Please ask for: Mrs D Johnson
Email: daun.johnson@arun.gov.uk
Telephone: 01903 737762
Our Ref: BN/139/20/PL
Your Ref:
Date: 24th November 2020

Application for Planning Permission

Development: 1 No dwelling. This site is in CIL Zone 3 and is CIL Liable as new dwelling.
Location: The Cottage Highground Lane Barnham PO22 0BT

SOUTH EAST ELEVATION
1:00

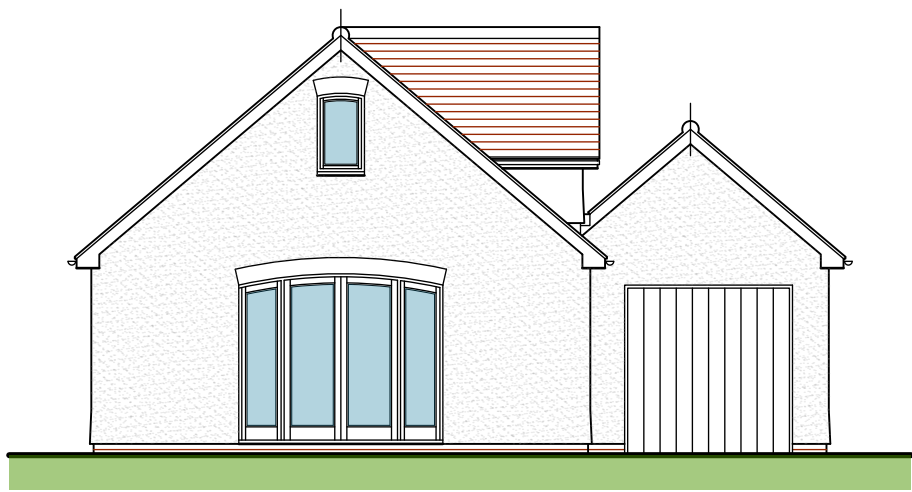
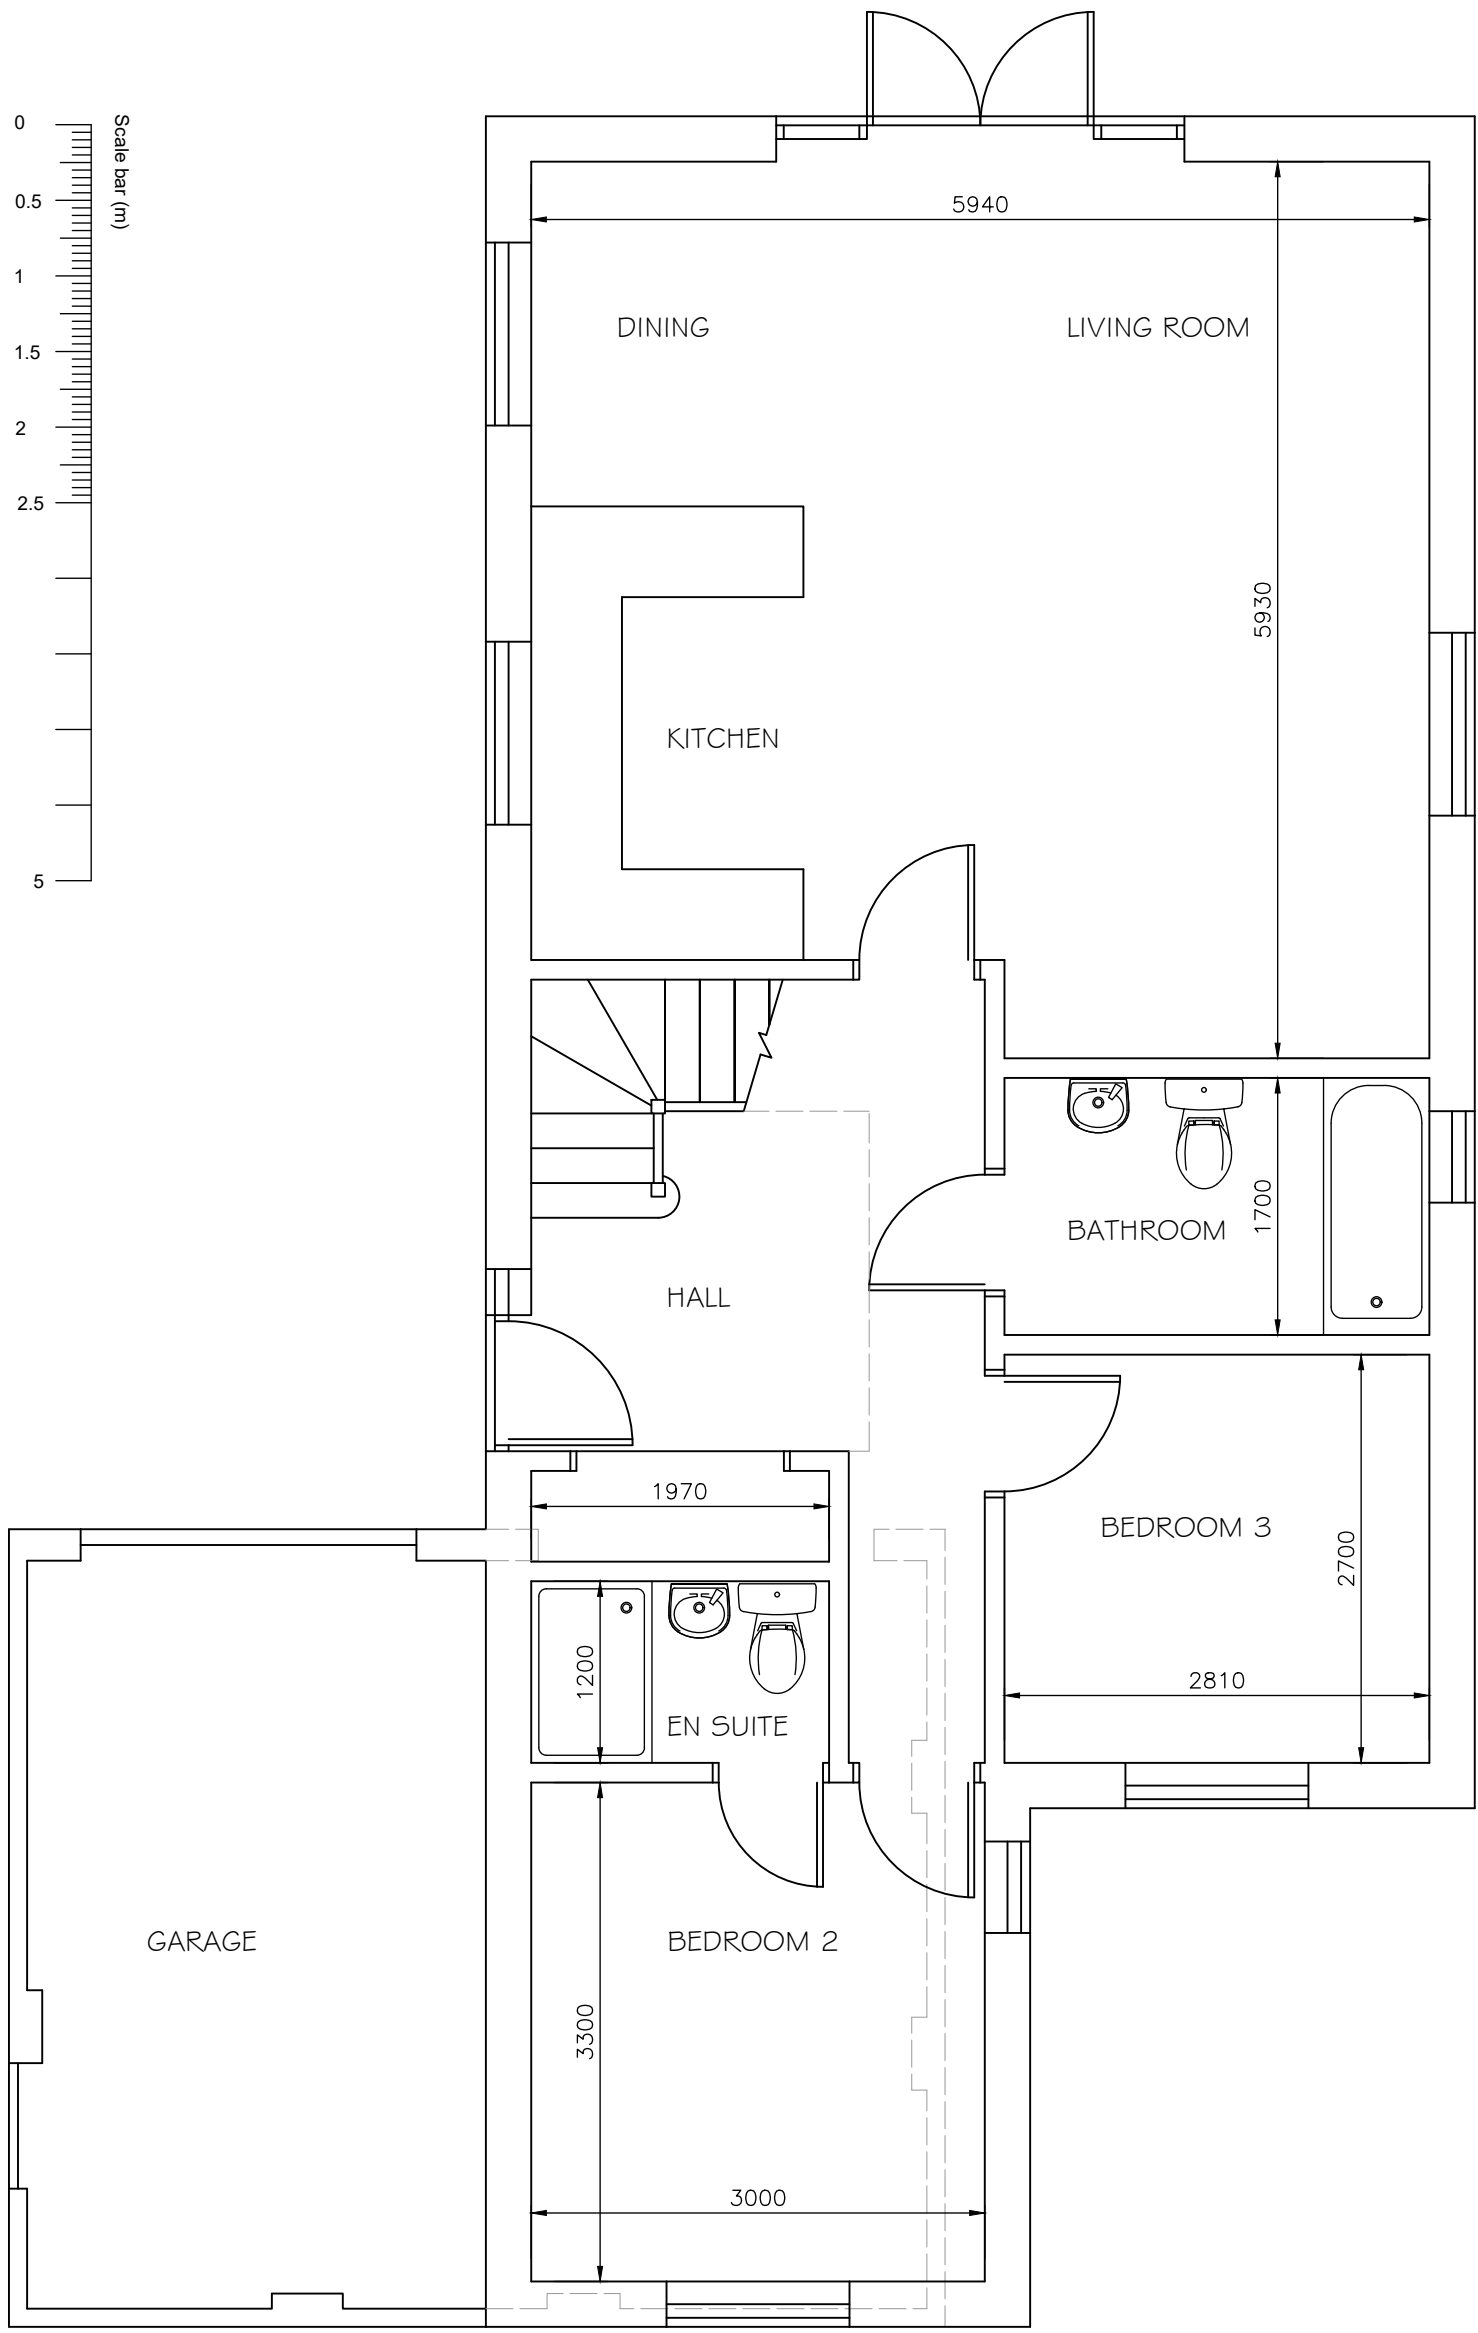
The proposed south east floor plan and elevation do not accord. Please amend accordingly.
